PUBLIC WORKS DEPARTMENT
Post Office Box 9010 Addison, Texas 75001-9010

October 25, 2007

Re: Plan Review
Lake Forest Addition

**GRADING & DRAINAGE PLAN**  
 LAKE FOREST ADDITION  
 TOWN OF ADDISON  
 DALLAS COUNTY, TEXAS

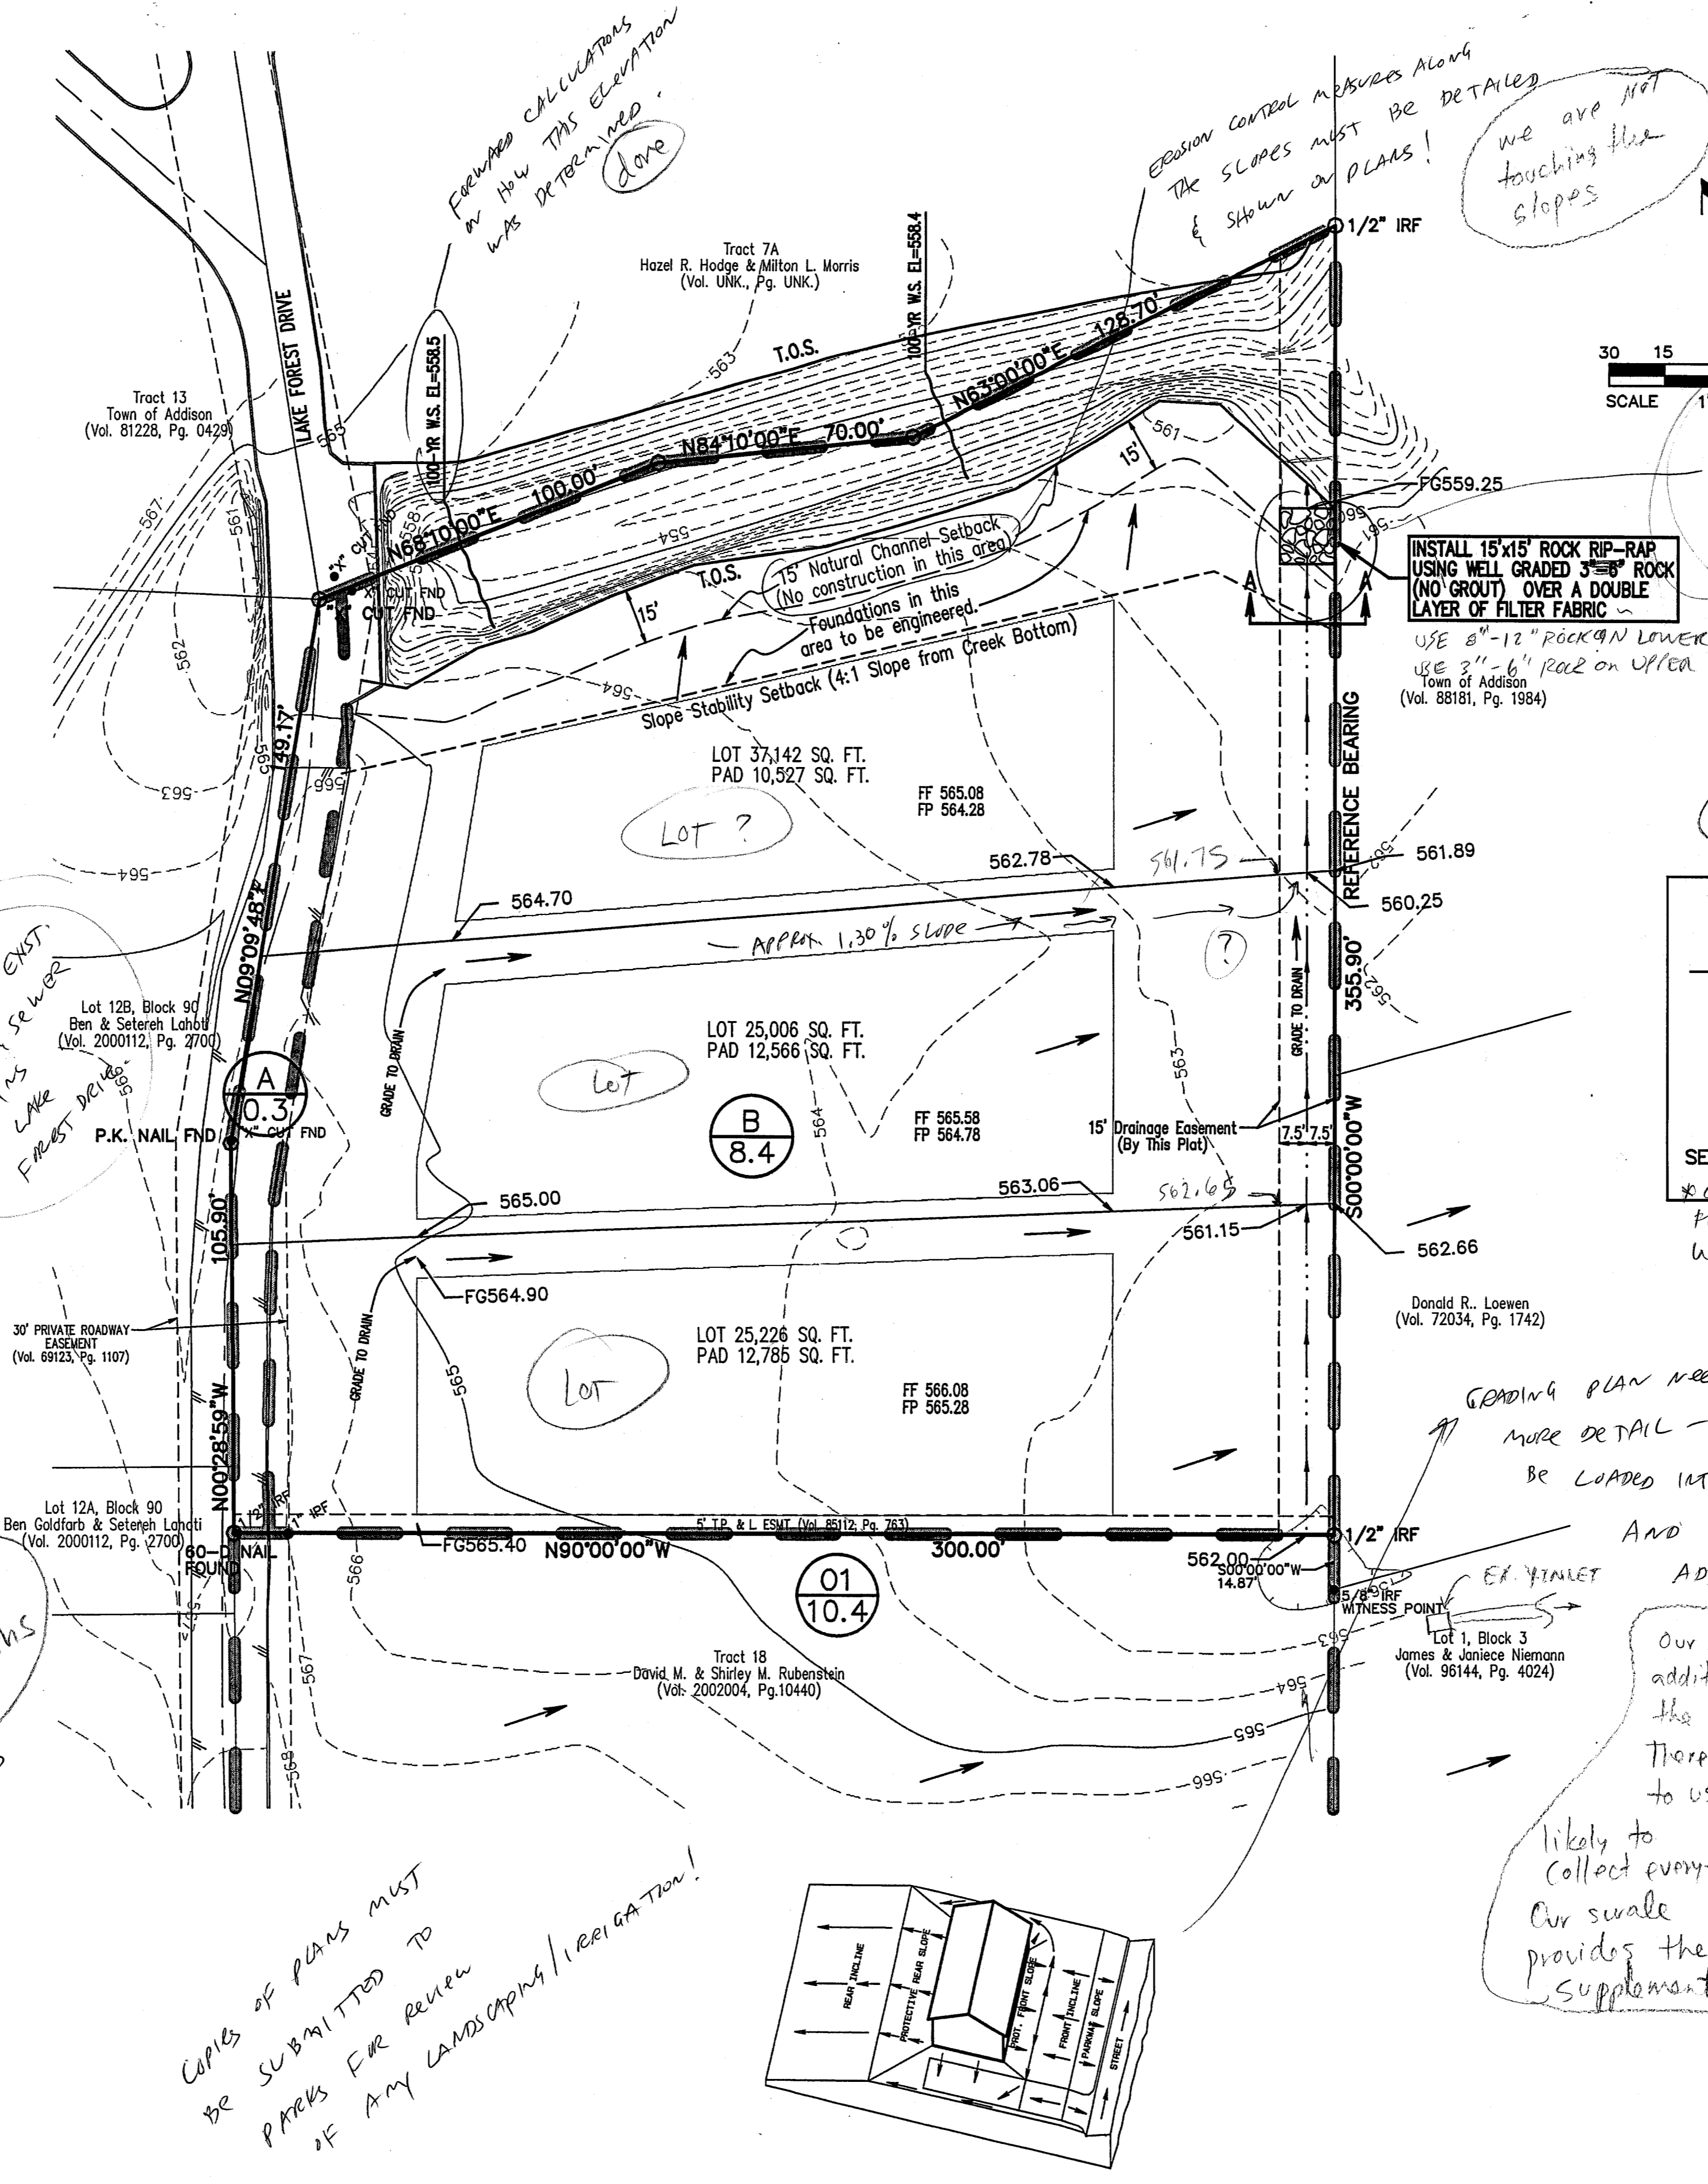
- a) Place silt fence at the top of slope along the natural channel.
- b) Provide a construction entrance.
- c) Indicate size and location of existing and proposed utilities.

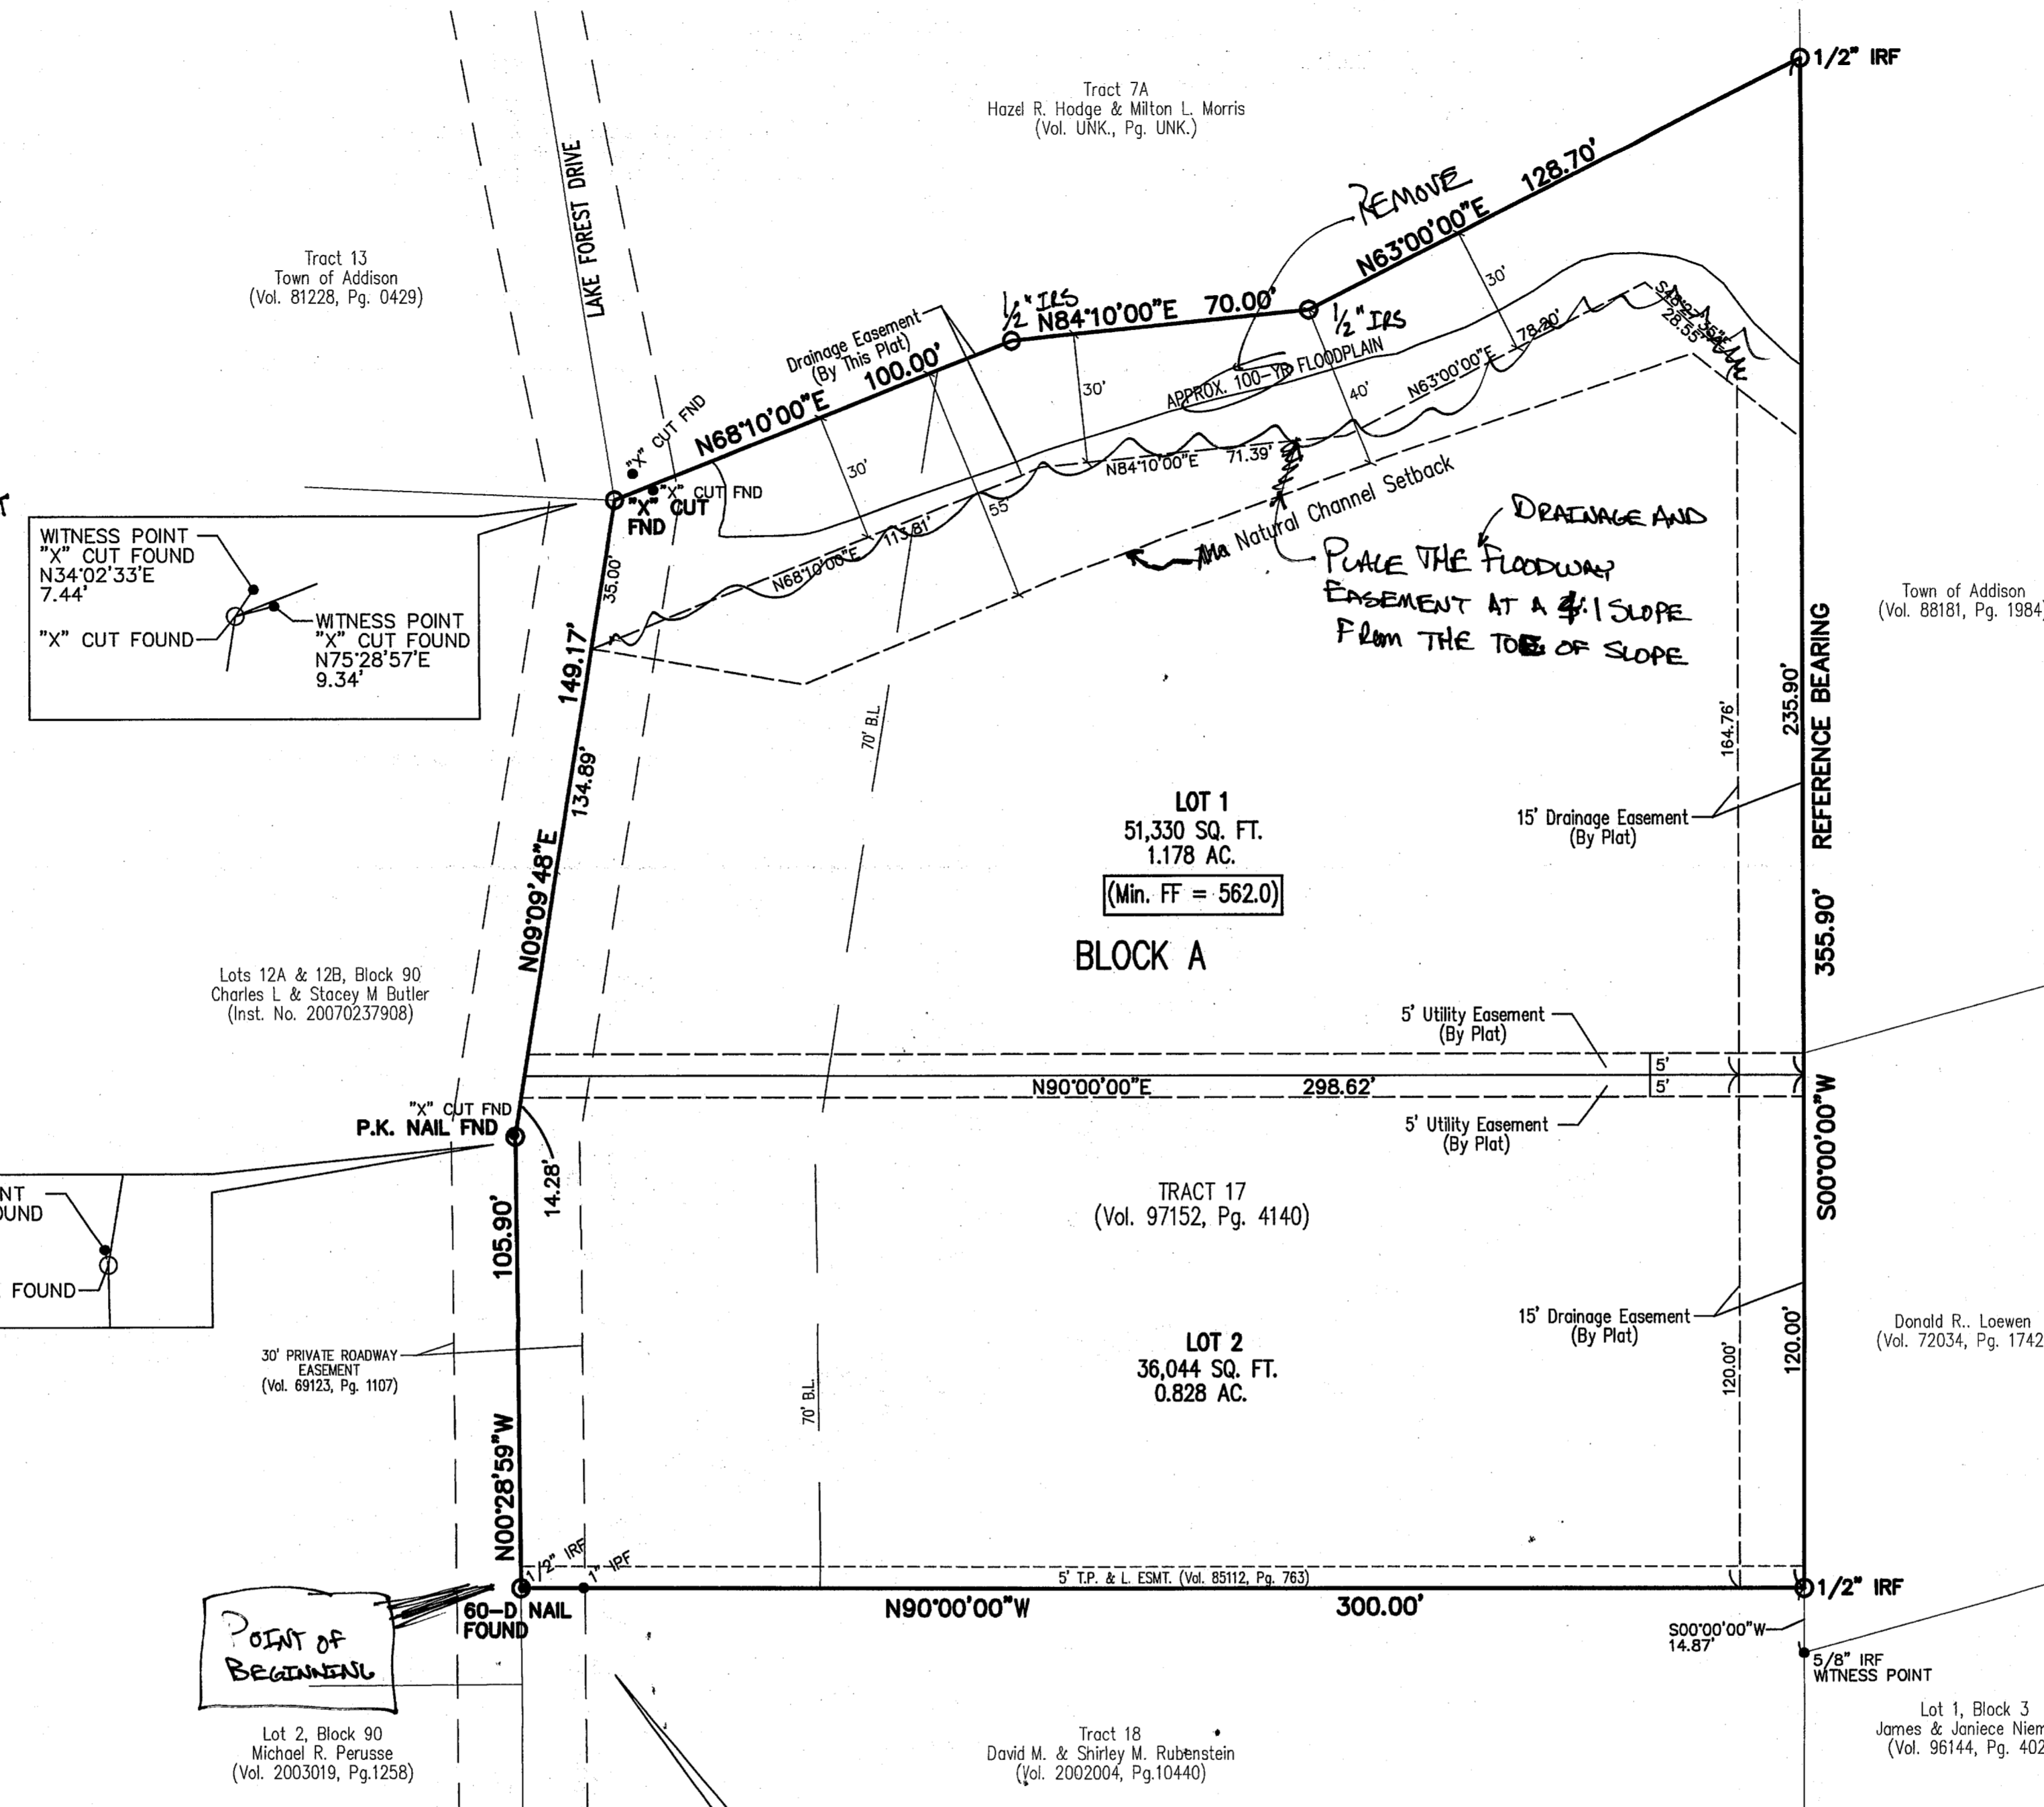
- a) A 1/2" iron rod needs to be set at the two points in the northern property line.
- b) The page of the instrument recorded in Volume 72034 does not match between the Owner's Certificate and the drawing. Please verify.
- c) Remove Owner's Dedication, State of Texas and County of Dallas from the middle of the Owner's Certificate.
- d) Indicate the "Point of Beginning" on the drawing.
- e) Remove the limits of the 100 year floodplain from the drawing.
- f) Remove the flood statement from the plat.
- g) Change "City of Addison" to "Town of Addison" in Note 1.
- h) Place the "Drainage and Floodway Easement" limits at a 4:1 slope from the toe of slope or at the limits of the 100 year floodplain, whichever is greater.
